**Application Reference:** 2025/1032

**Site Address:** 102 Manchester Road, Thurlstone, Sheffield, S36 9QW

This application seeks full planning permission for a single storey side extension and dropped kerb, located at 102 Manchester Road, Thurlstone, Sheffield, S36 9QW.

PROPOSED PLANS & ELEVATIONS

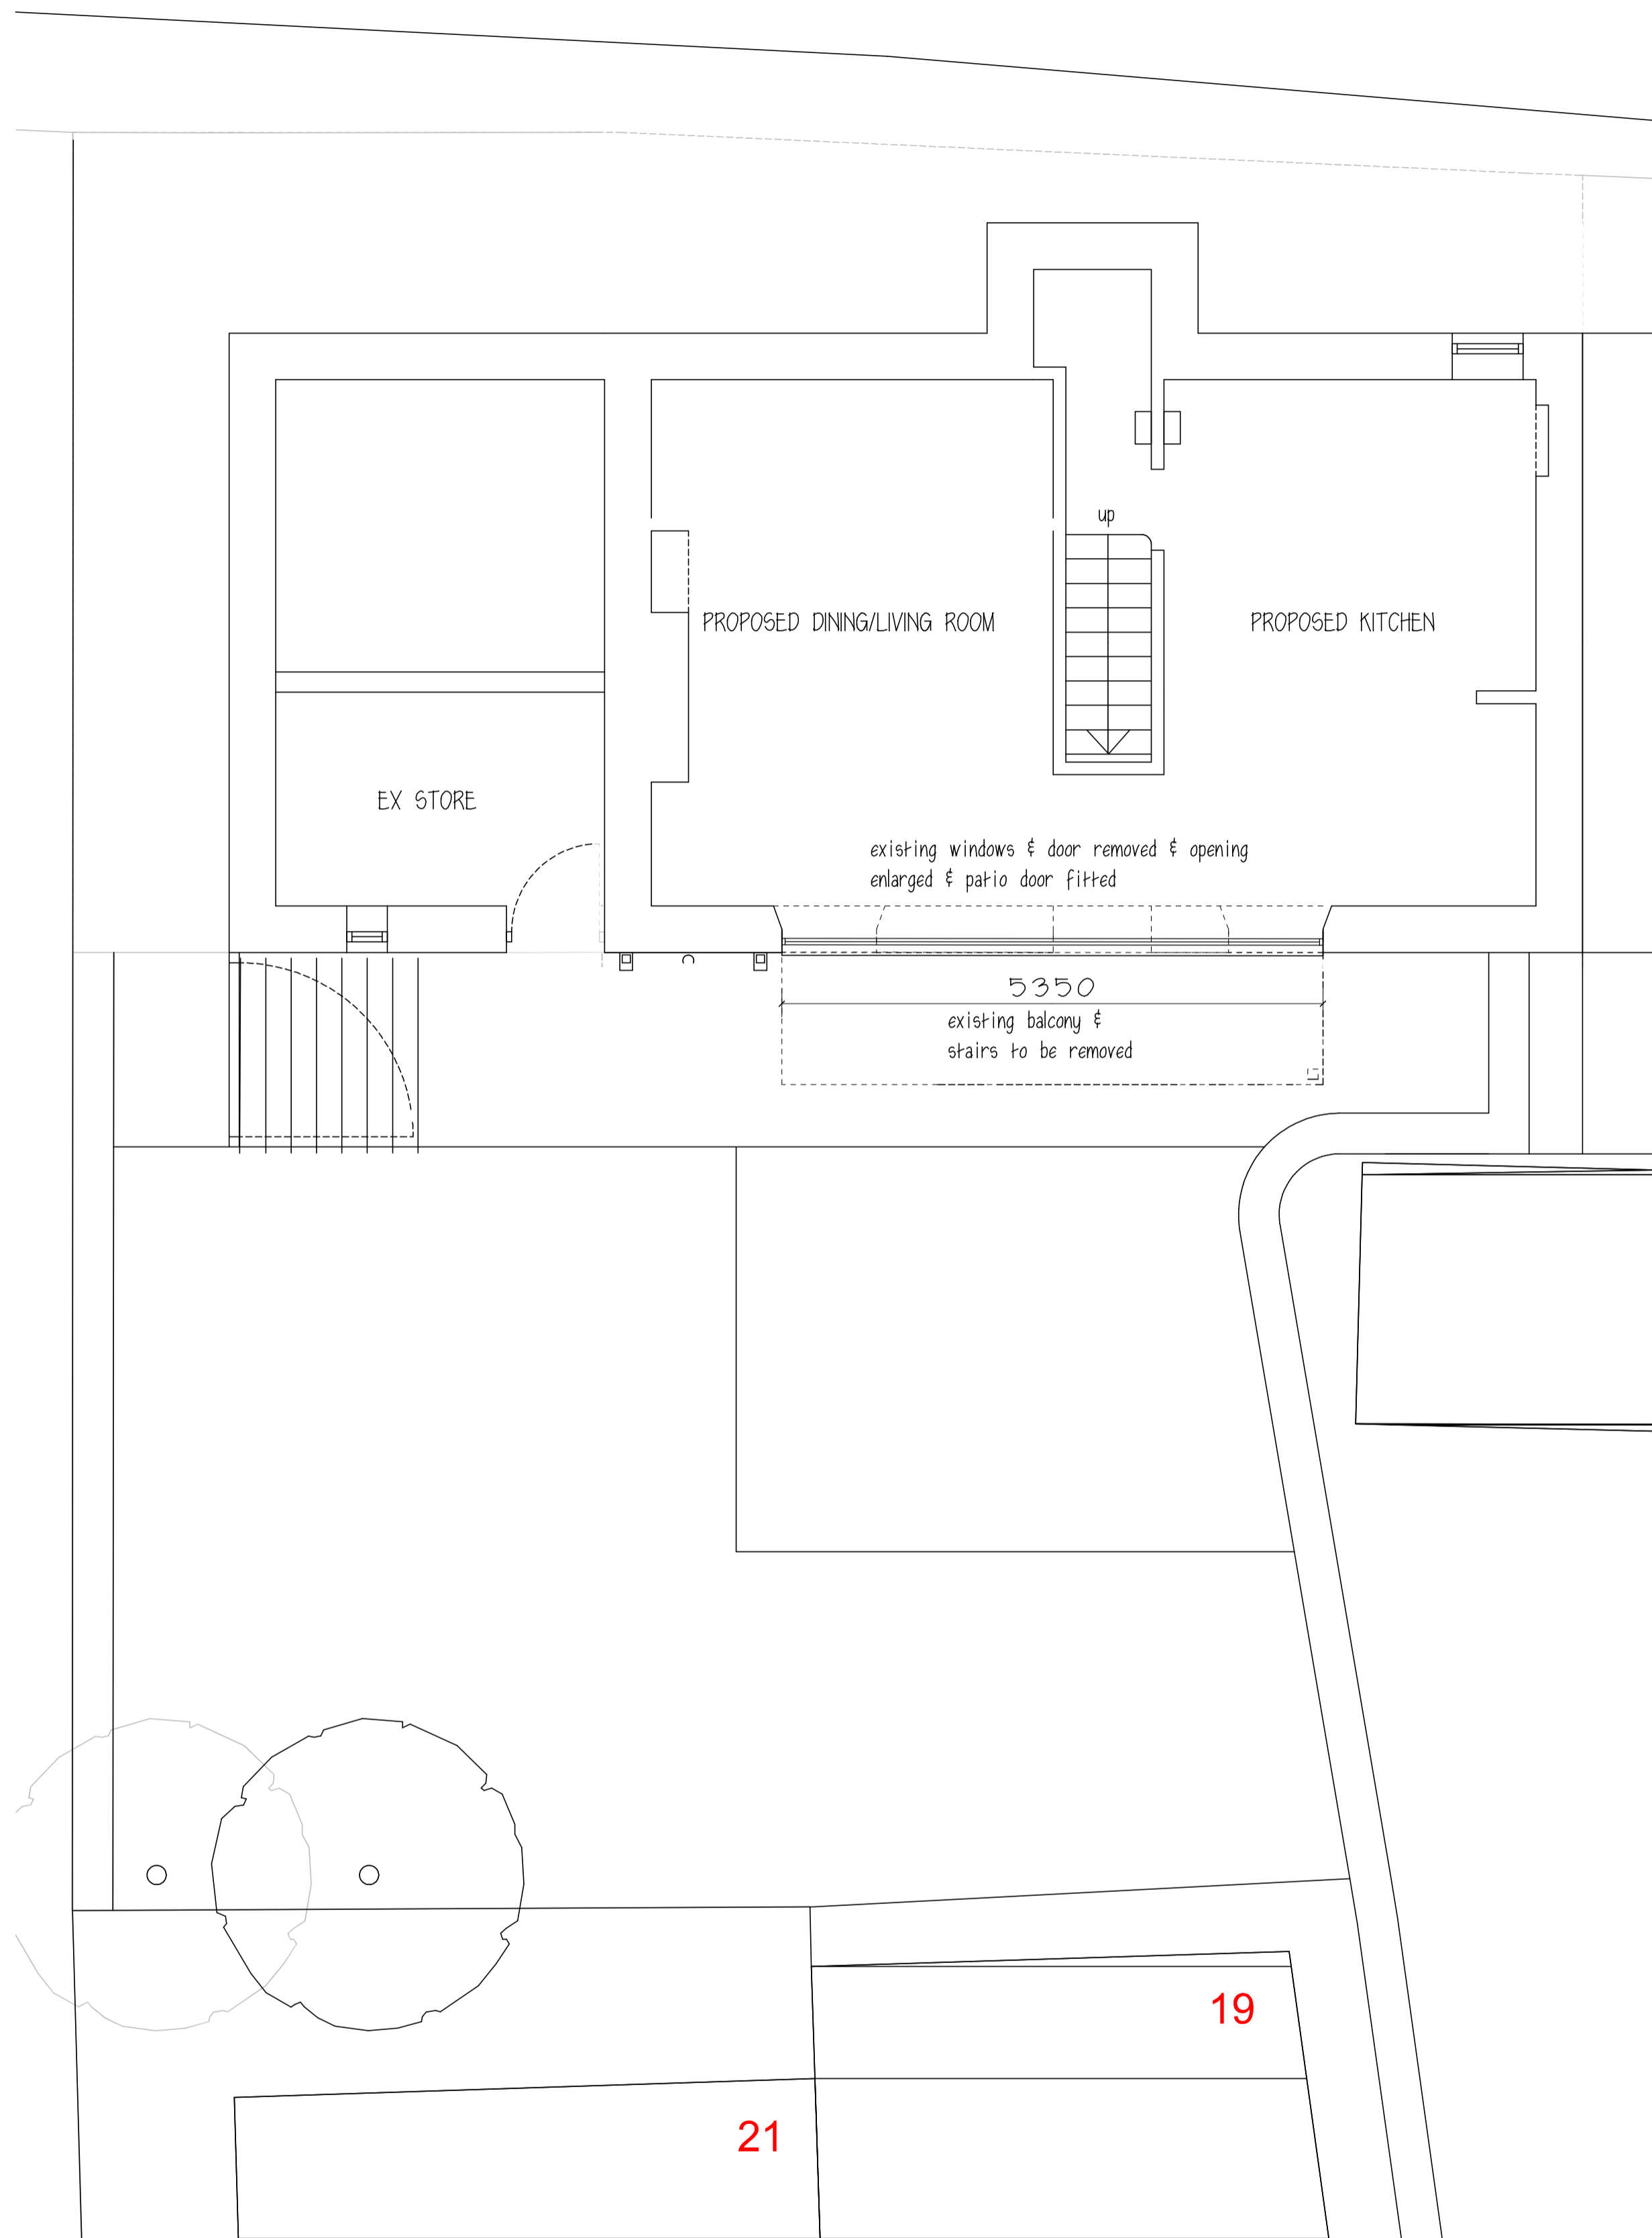
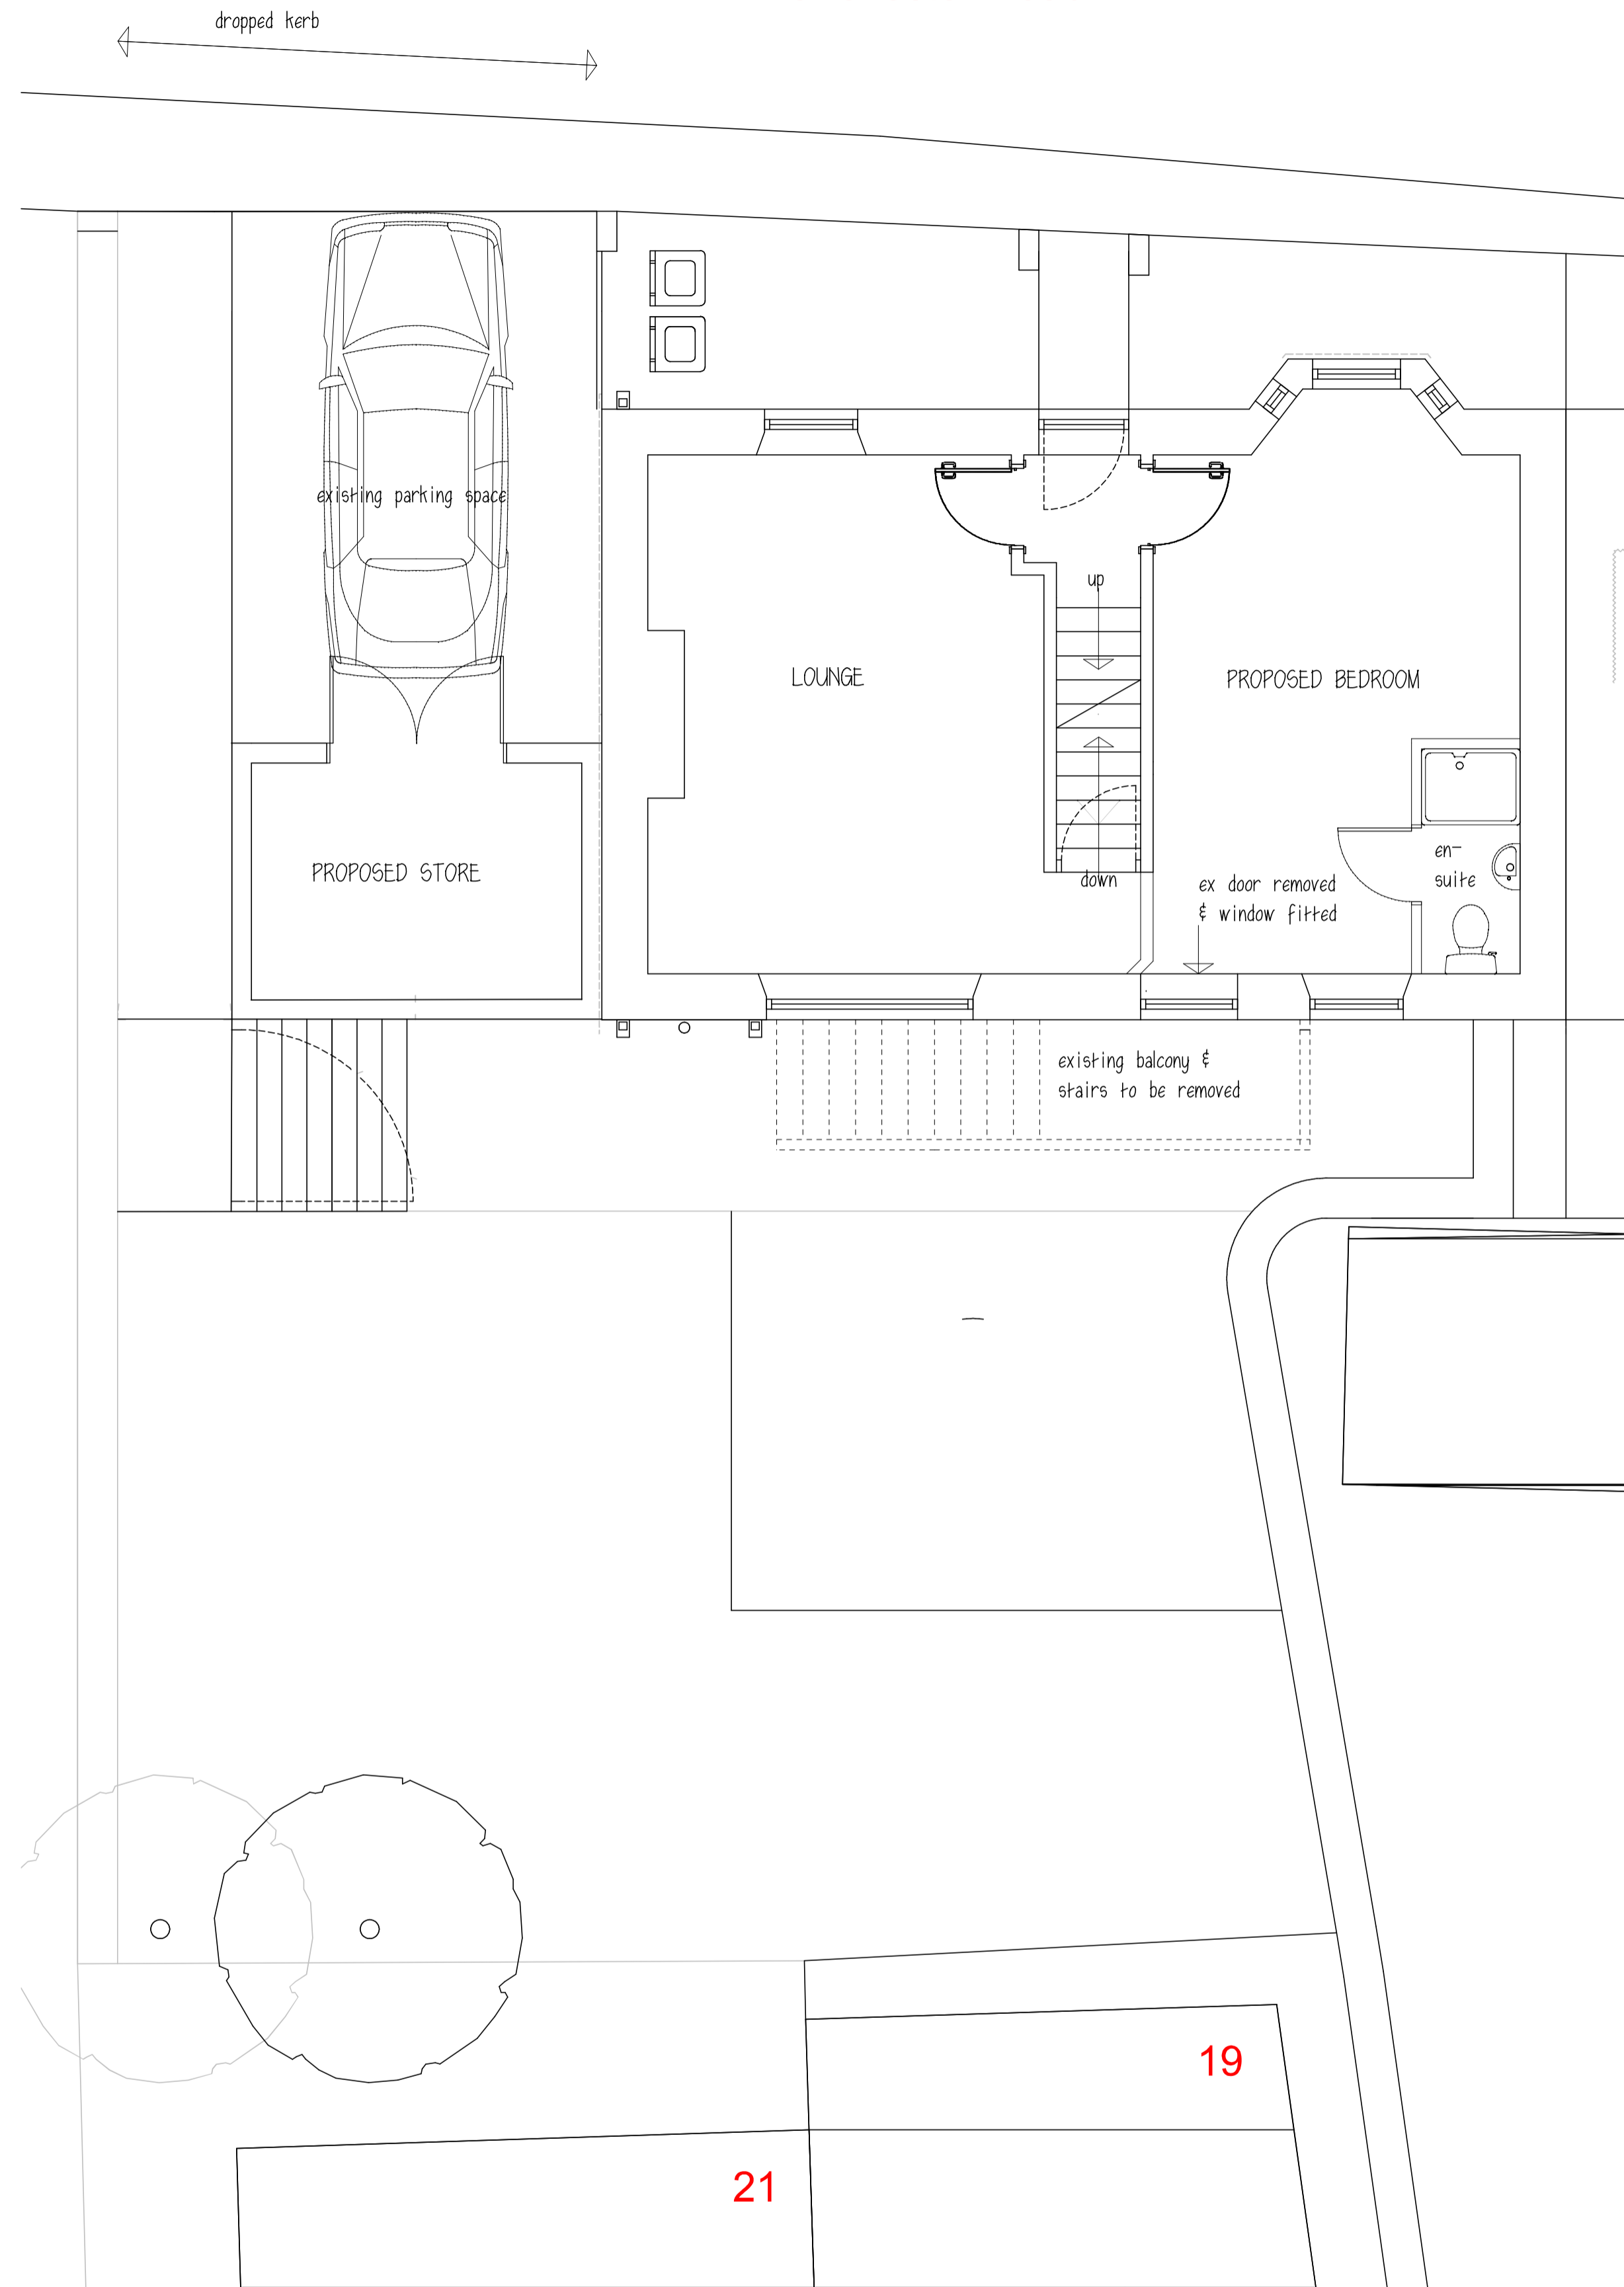
It should be noted that the applicant has not provided all the floor plans necessary. The applicant has provided the basement/ground floor plan and the ground floor plan. However, they have not provided the 1<sup>st</sup> floor plan.

The applicant would like to incorporate another bedroom into the current dwelling on the ground floor. However, as mentioned before the applicant has not provided all the necessary floor plans, as such the LPA cannot accurately assess how many bedrooms are at the site or if any other changes will be being made. On their own, internal alterations such as this would not require planning permission but the lack of full information of floor plans makes a full assessment with regards to suitable amenity space and parking provision.

The proposal would create a permanent storage space adjacent to the dwelling and also formalise an off-street parking space by installing a dropped kerb to allow access off Manchester Road.

Highways DC officers would expect internal turning to be provided off a classified road to allow vehicles to enter and exit the highway in a forward gear. It was noted in 2023 that “On both the easterly and westerly approaches to the site, visibility is obscured due to on street parking and alignment of the carriageway. In some situations, the access would be completely concealed from view. Due to the prevalence of on-street parking in the area, it is necessary for cars travelling east along Manchester Road to encroach into the opposing carriageway lane to pass parked vehicles for considerable lengths and those travelling in a westerly direction to be aware of this and potentially give way to oncoming traffic. There is also a bus stop opposite and to west slightly of the site. Furthermore, the footway reduces in width significantly, directly adjacent to the property, which could result in pedestrians having to step out into the carriageway. All of these factors result in drivers having to be very aware of their already busy surroundings and the introduction of an obscured vehicular access that subsequently does not meet the required minimum standards, gives rise to serious road safety concerns”.

These concerns remain, and HDC officers would therefore not wish to see this hard-surfaced area formalised as a parking space for the above safety reasons and so as not to set a precedent of providing substandard off-street parking facilities on this busy, A-classified road. Objection is therefore raised on highway safety grounds. Substantial planning weight should be given to this as there are safety concerns for members of the public.
